**J.S. THOMPSON**  
ENGINEERING, INC

September 5, 2024

The "Franklin" plan was reviewed for lot #9 Magnolia Acres subdivision in Fuquay-Varina, North Carolina to address the garage beam.

FIRST FLOOR PLAN
 1/4" = 1'-0"

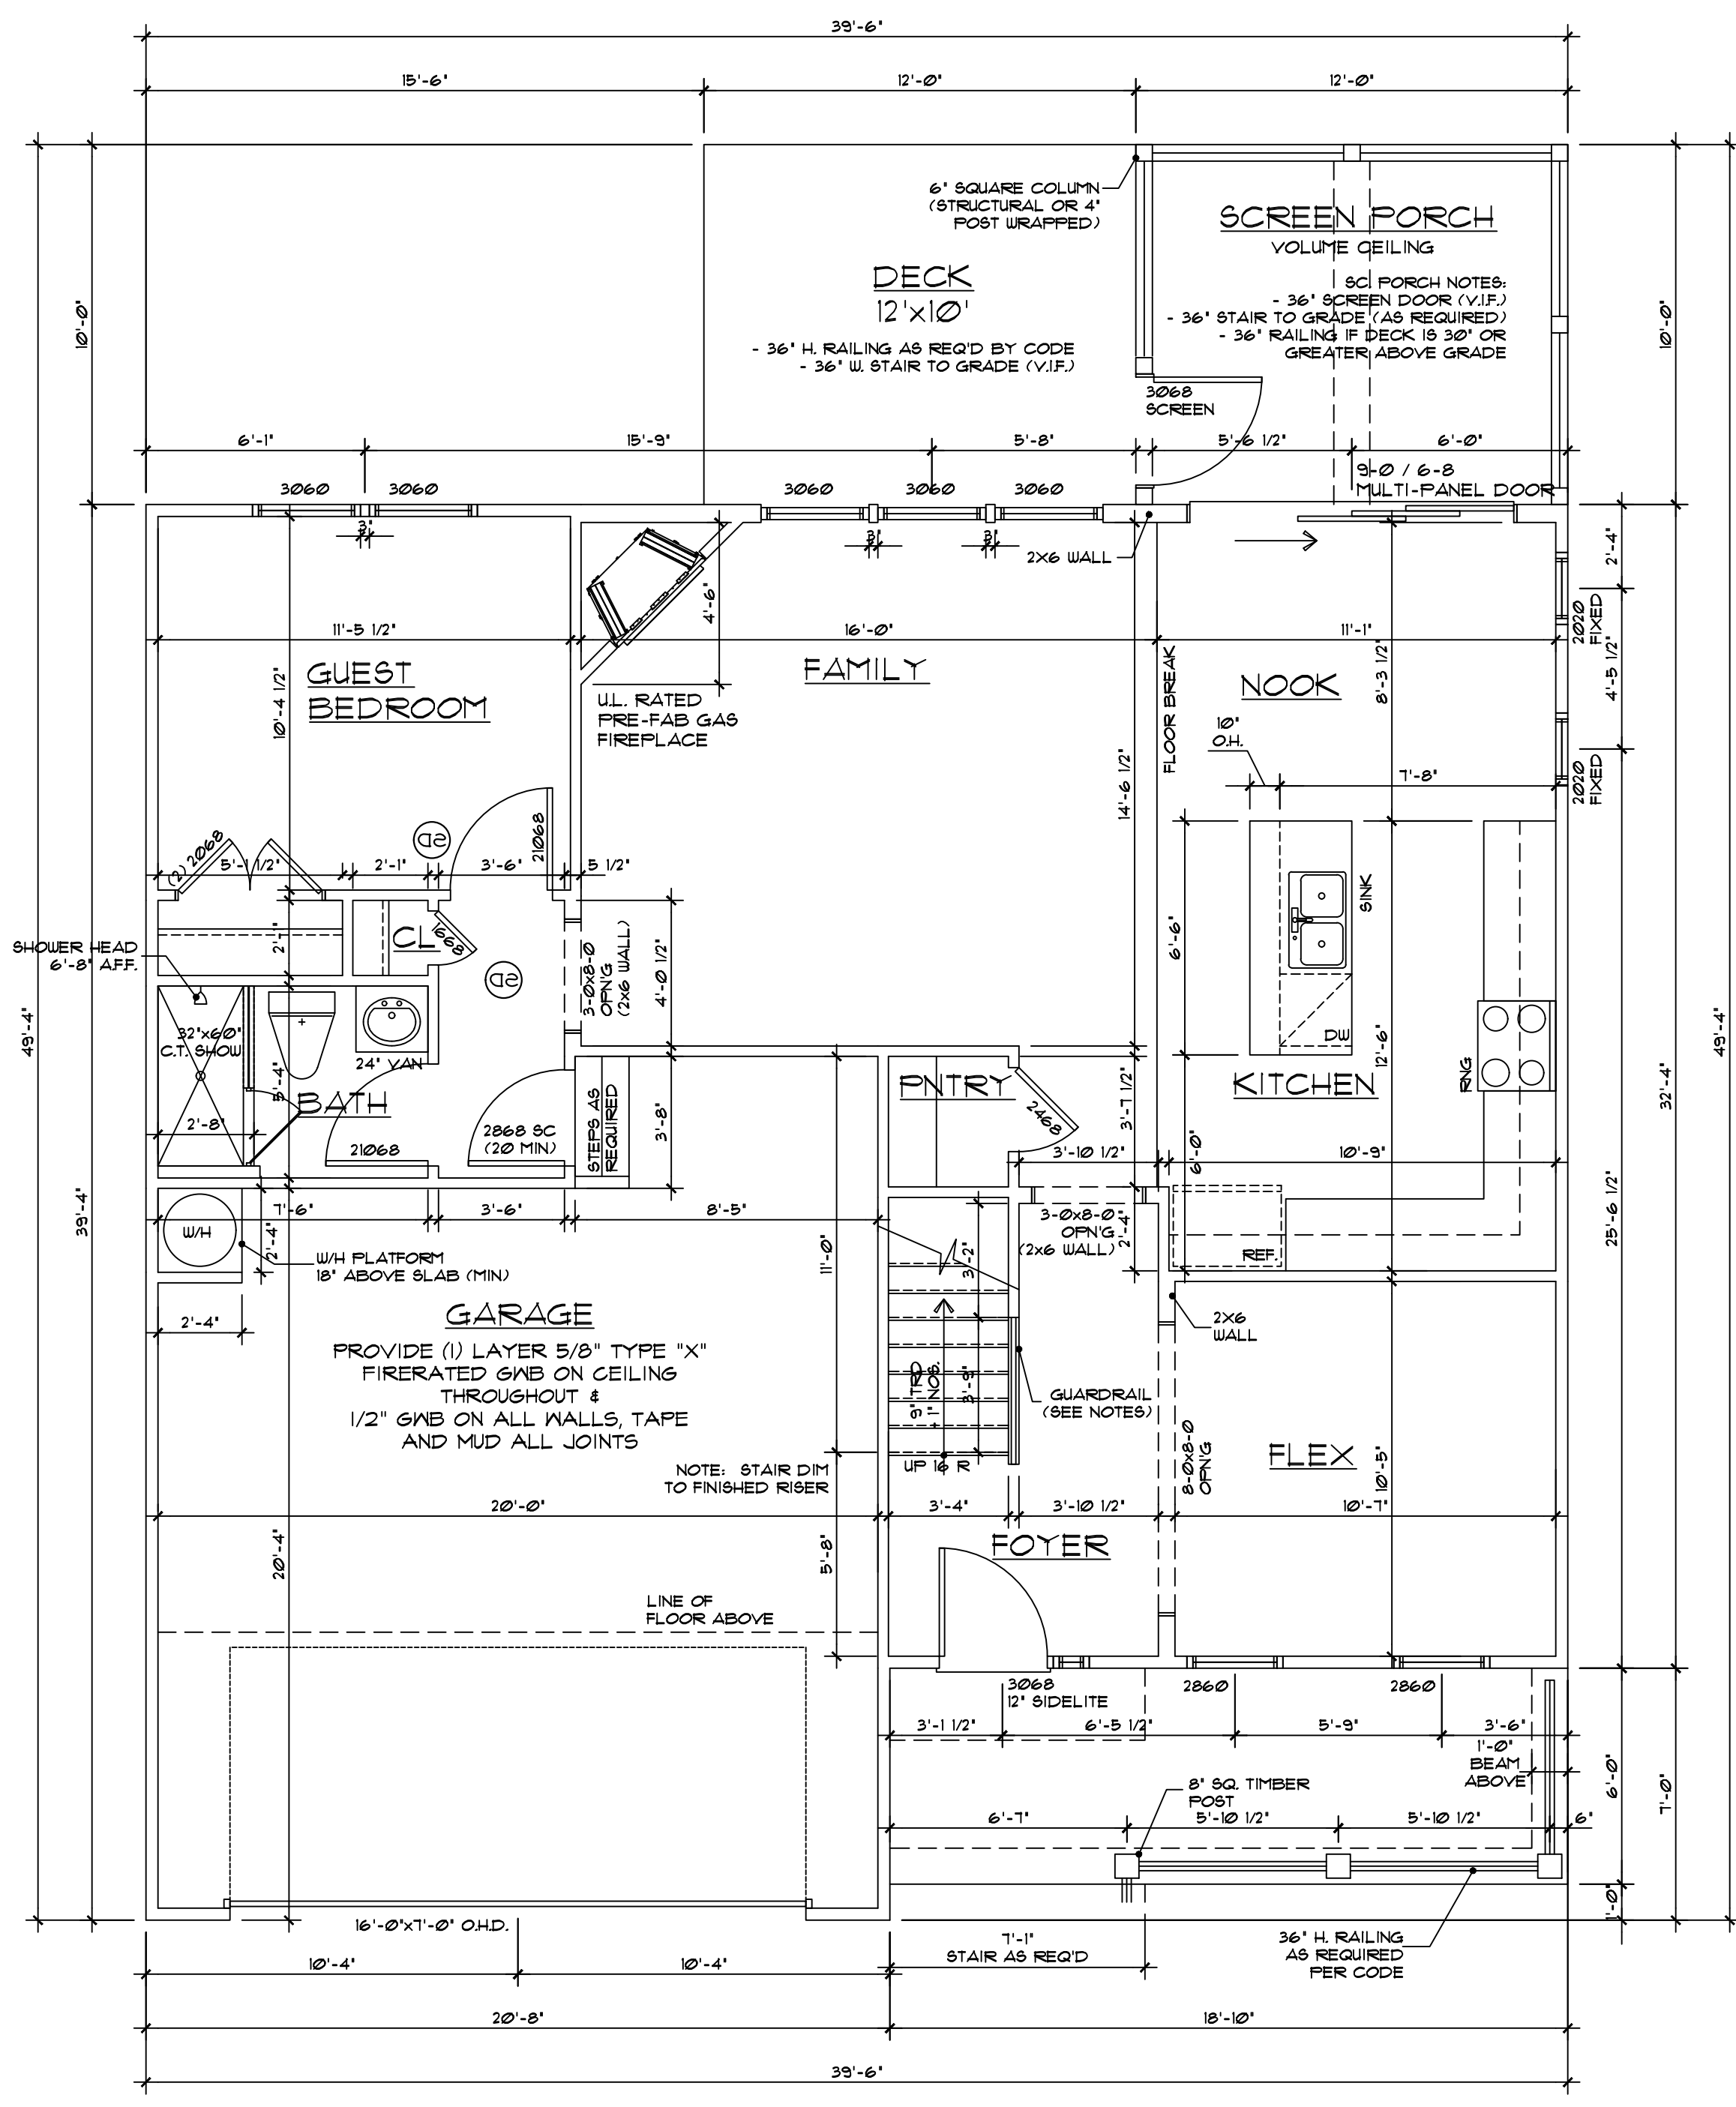
The "as-built" (2) 1 3/4" x 24" LVL above the garage bearing on the LVL plate in lieu of bearing directly on the jacks per plan is suitable. This configuration will provide the required support for all applied loads.
